PLANNING DEPARTMENT
DEVELOPMENT SERVICES DIVISION
600 2nd Street NW, Ground Floor, 87102
P.O. Box 1293, Albuquerque, NM 87103
Office (505) 924-3946

OFFICIAL NOTIFICATION OF DECISION

Carlos Zamora 8001 Shiprock Ct. NW Albuquerque, NM 87120 Project# PR-2022-006500
Application#
SD-2022-00032 PRELIMINARY/FINAL PLAT

SKETCH PLAT
Lot 17-A1, Block 7
Volcano Cliffs Unit 5

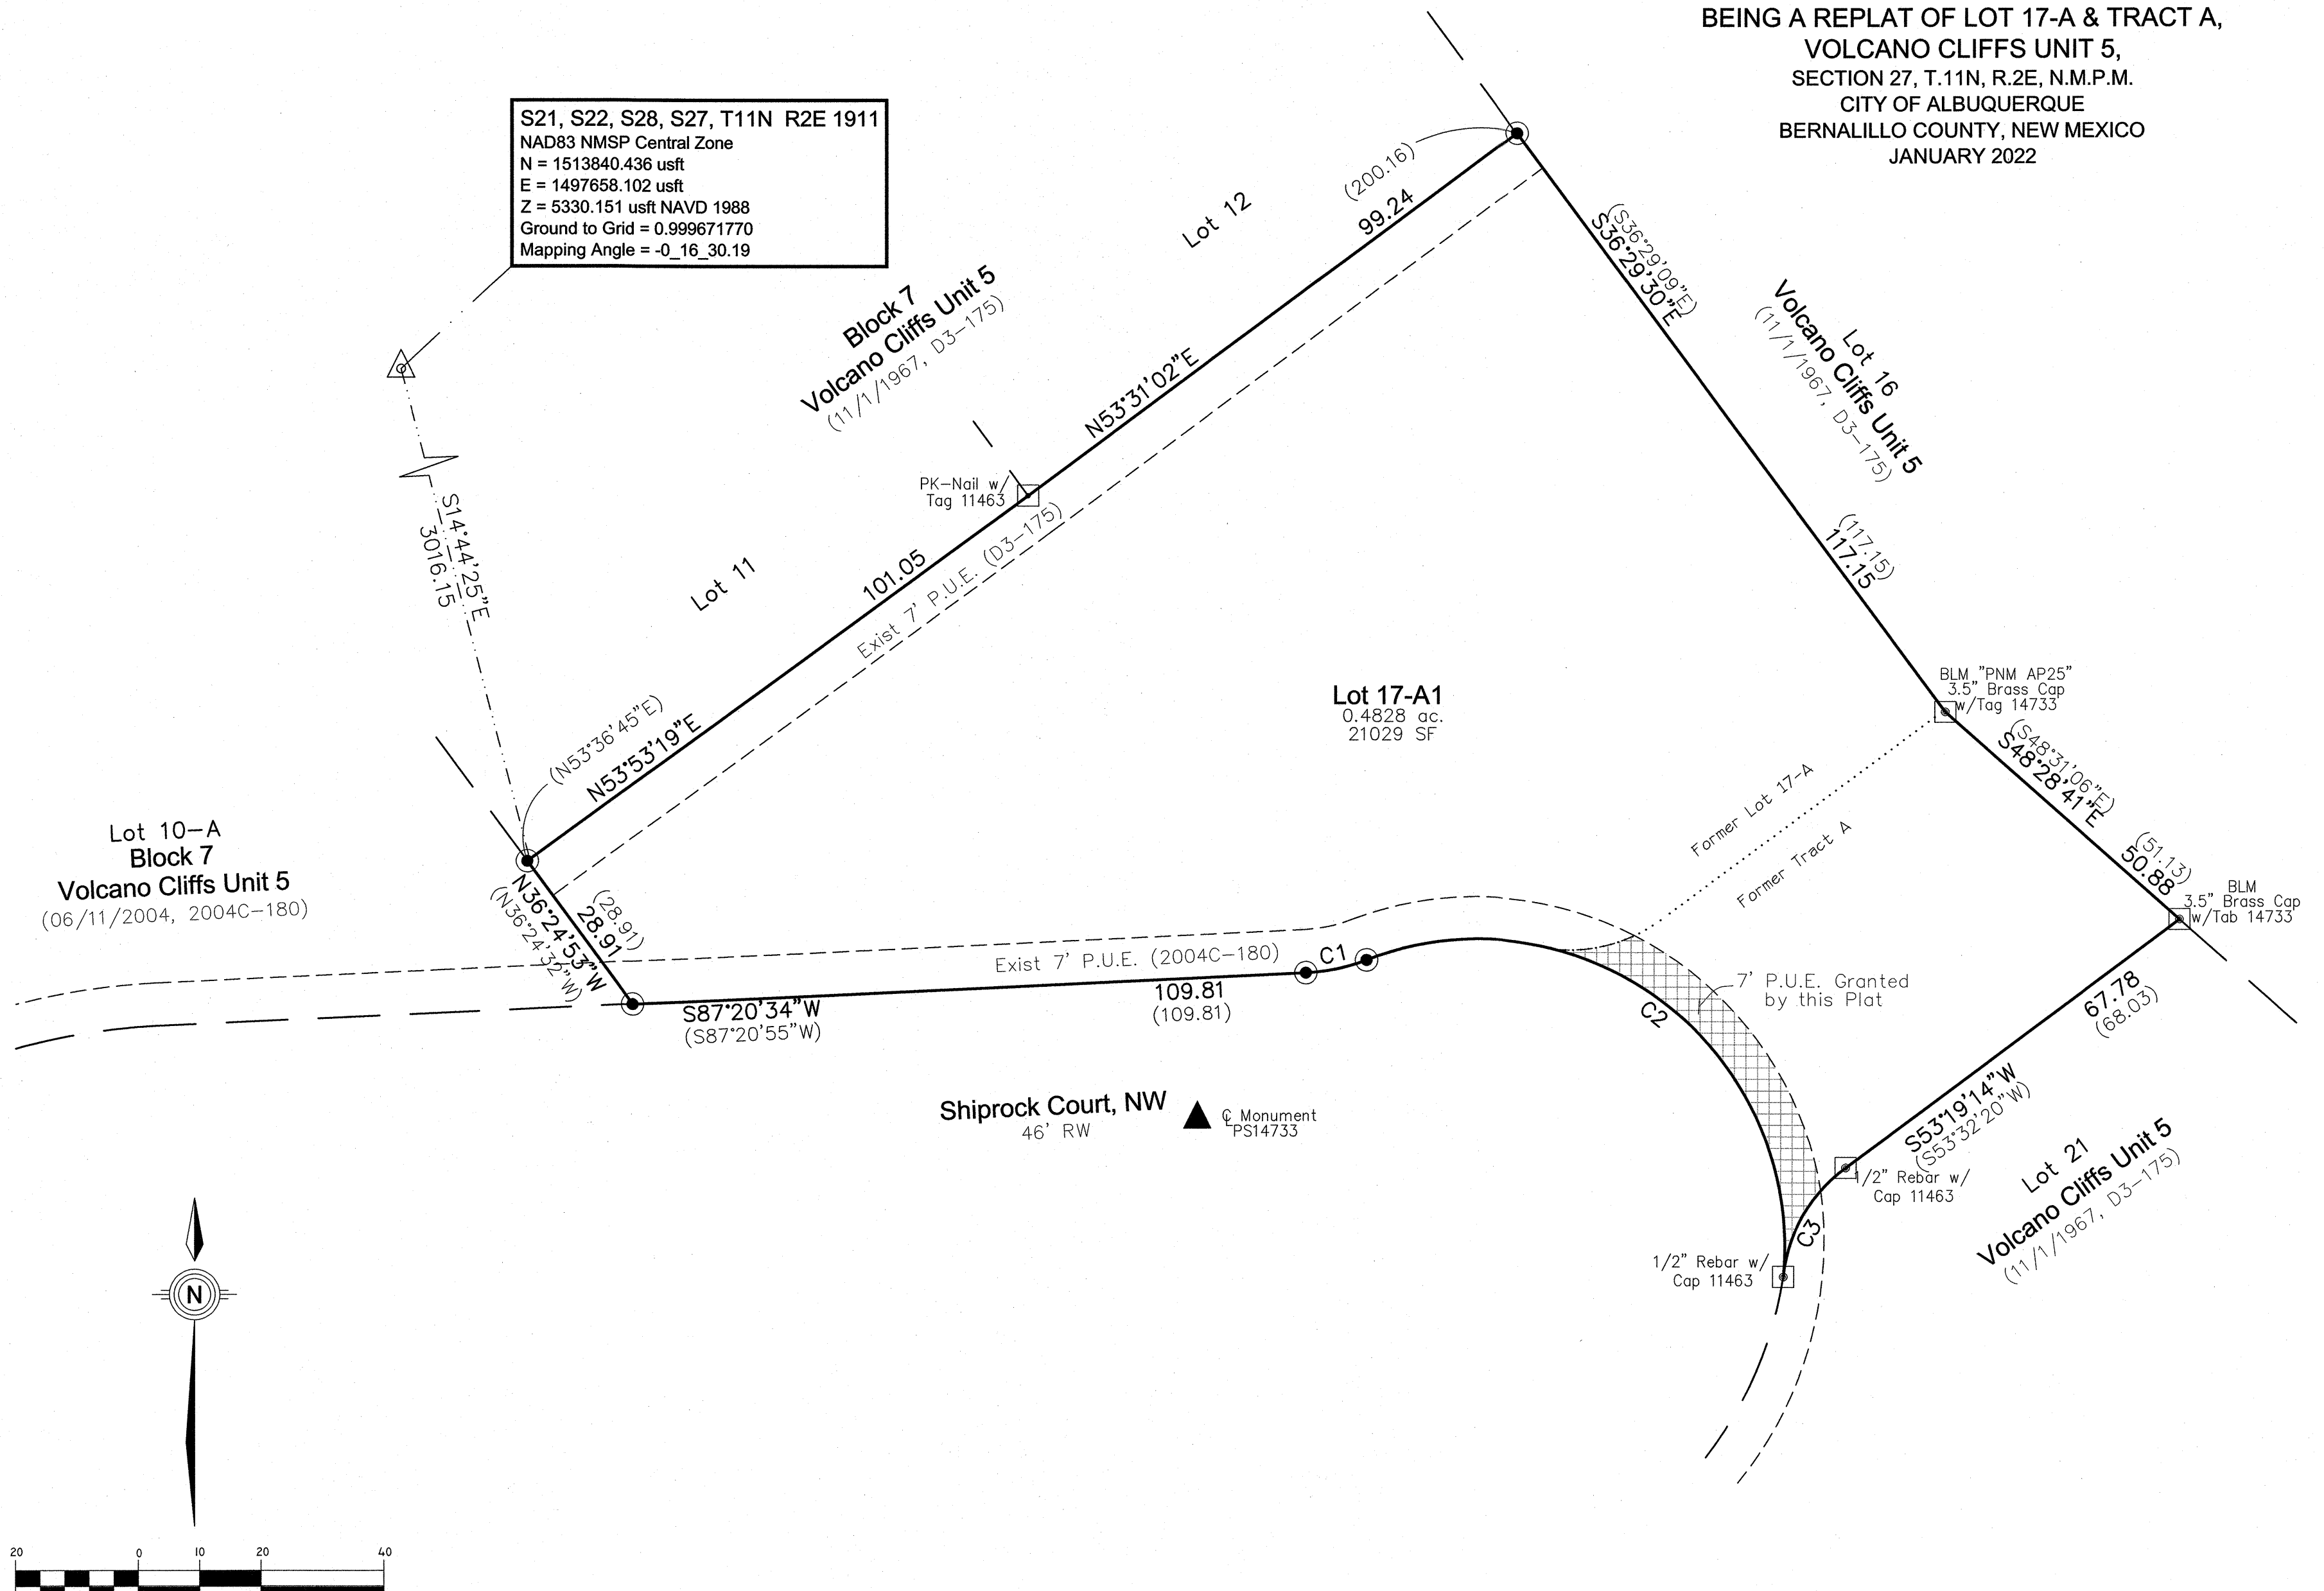
- 1. Final sign off is delegated to Hydrology for indication that Shiprock Court is to be shown on Tract A.
- 2. Final sign off is delegated to Planning for revision to the Plat to reference the 45-foot buffer adjacent to open space, for utility/AMAFCA signatures, the AGIS DXF file, and for the project and application numbers to be added to the Plat.
- 3. The applicant will obtain final sign off from Planning by May 4, 2022 or the case may be scheduled for the next DRB hearing and could be denied per the DRB Rules of Procedure.
